REFUSAL OF PLANNING PERMISSION

APPLICATION NO. 2018/1328

Proposal Erection of detached dormer bungalow

At 11 Broom Croft, Stainborough Lane, Hood Green, Barnsley, S75 3EZ

TITLE
DRAWING SHOWING SITE LAYOUT WITH POSITION
OF NEW BUNGALOW

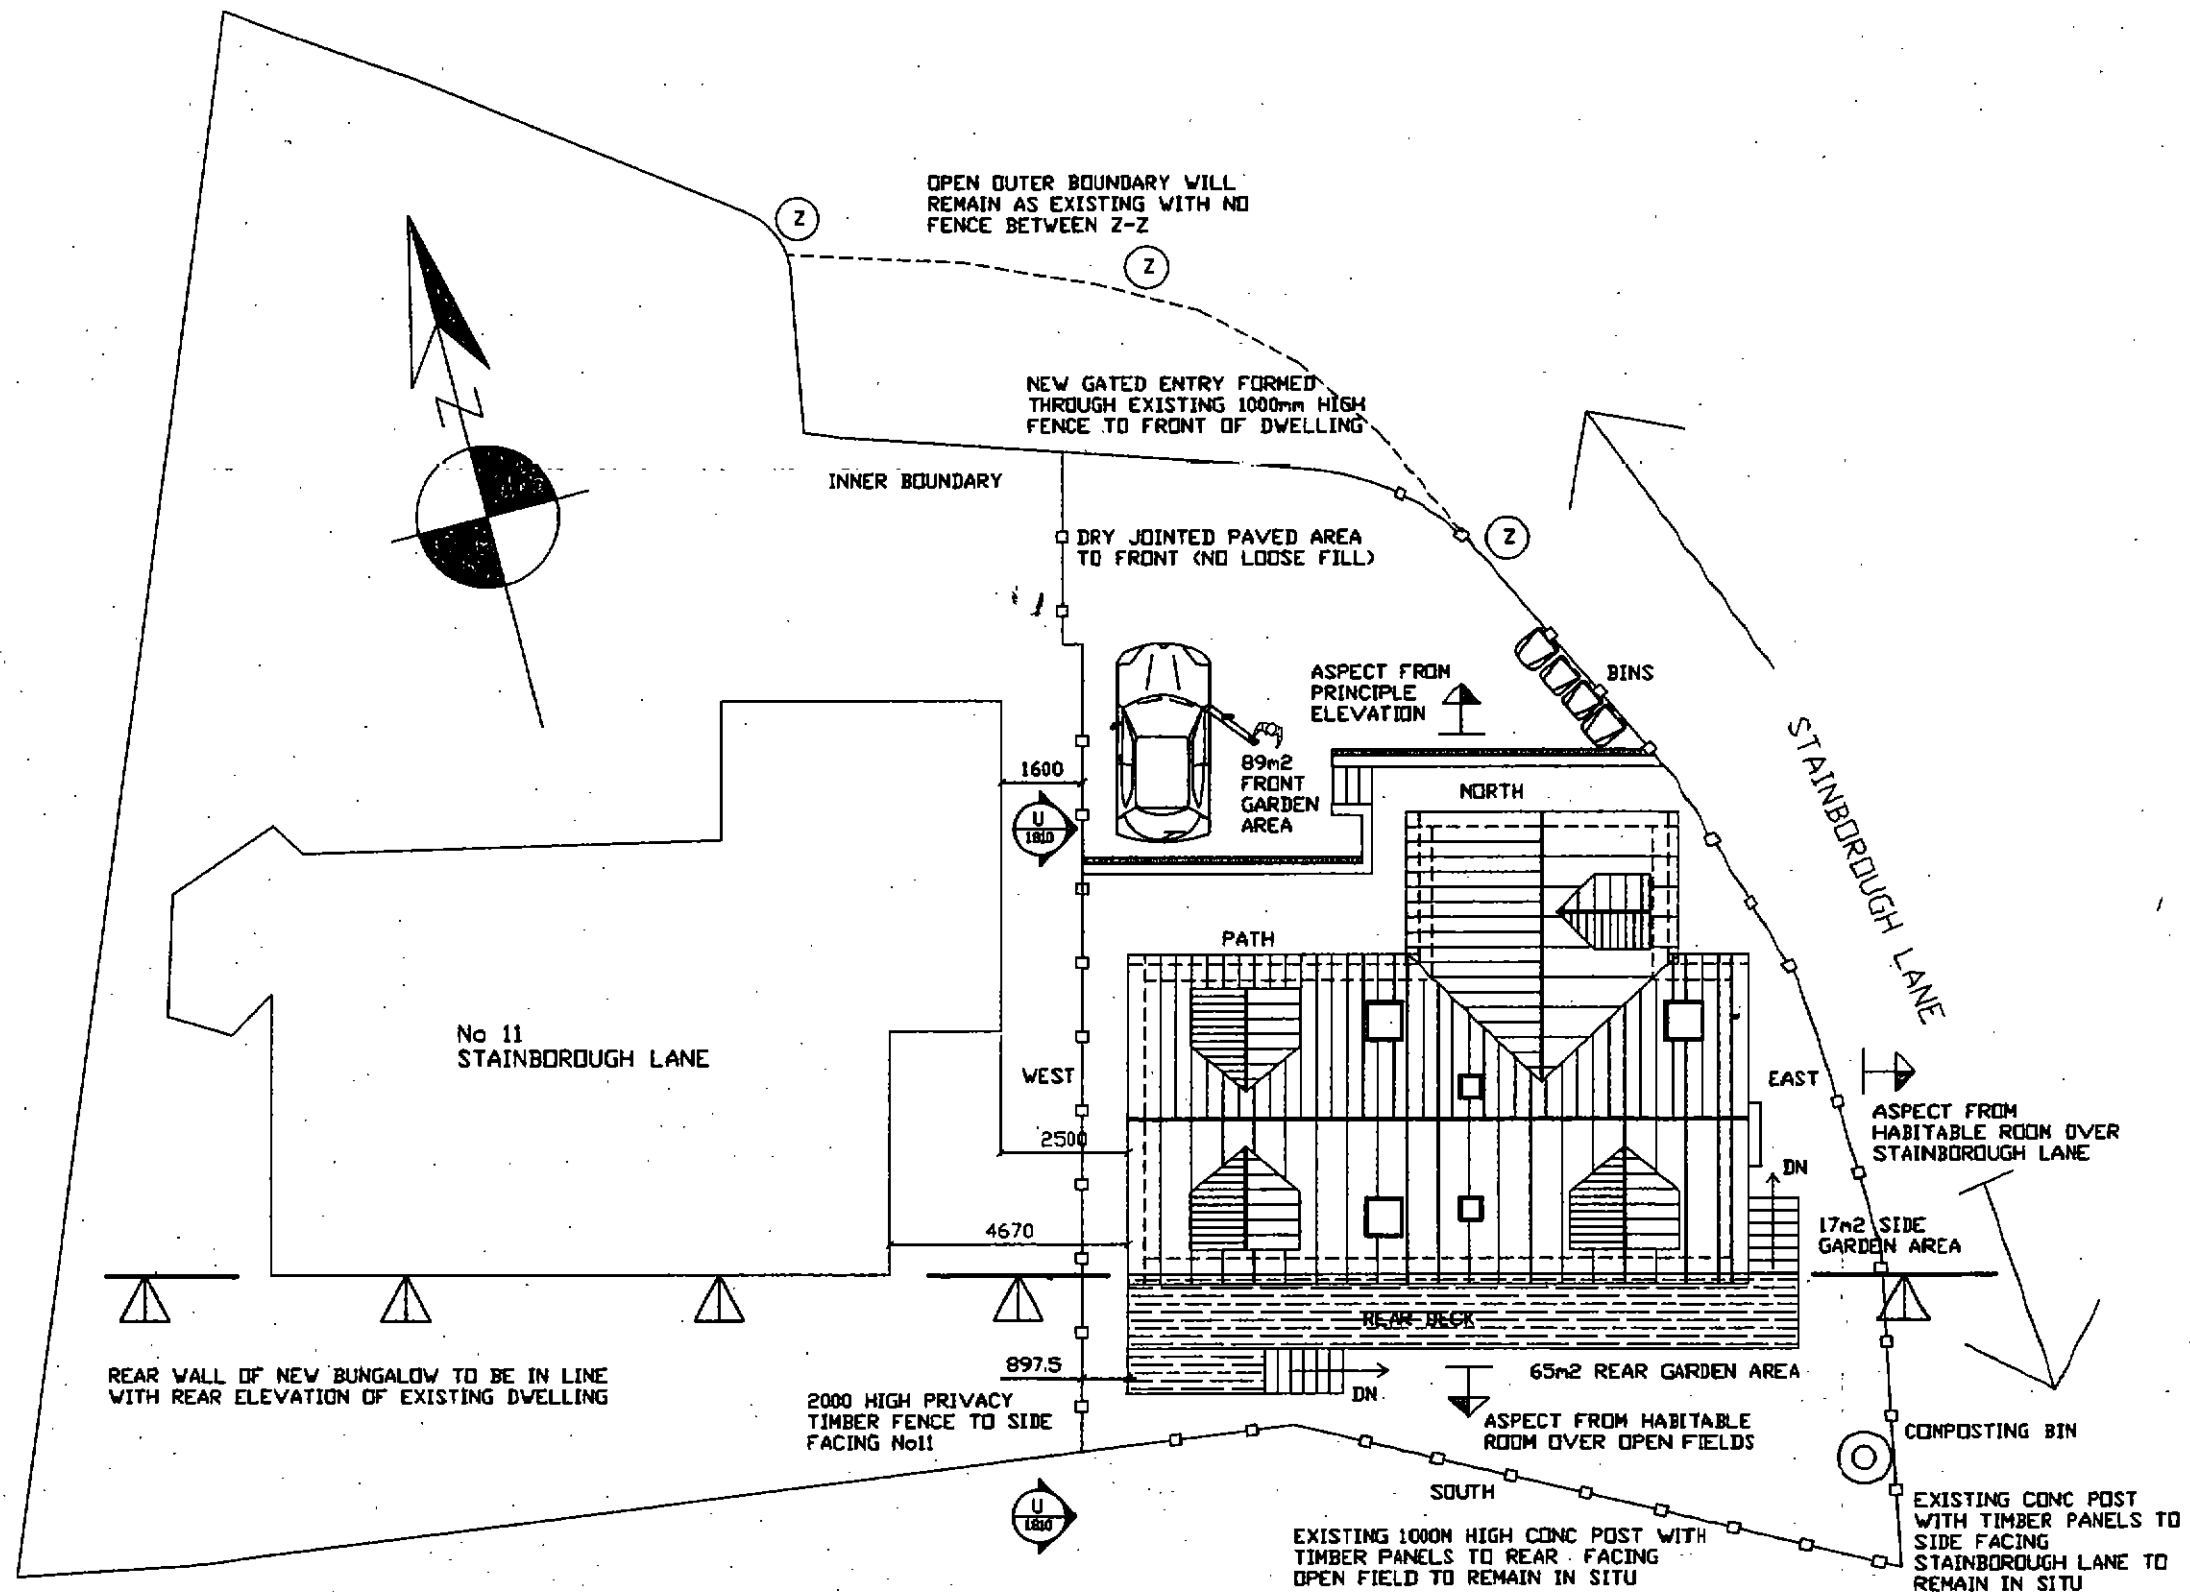
- 1 In the opinion of the Local Planning Authority the proposal represents overdevelopment of the site and an undesirable form of infill development. As a consequence, it would have an adverse impact on the setting of the original dwelling and the character and appearance of the street scene at a site located on the edge of a rural village adjacent to the boundary with the Green Belt. In addition the development would appear cramped due to the close proximity of the development to the northern and eastern boundaries and the shallow garden depths proposed for both properties. Accordingly the proposal is contrary to Local Plan policies H9 Protection of Existing Larger Dwellings, D1 High Quality Design and Place Making, the Designing New Housing Development SPD and paragraph 127 of the NPPF.
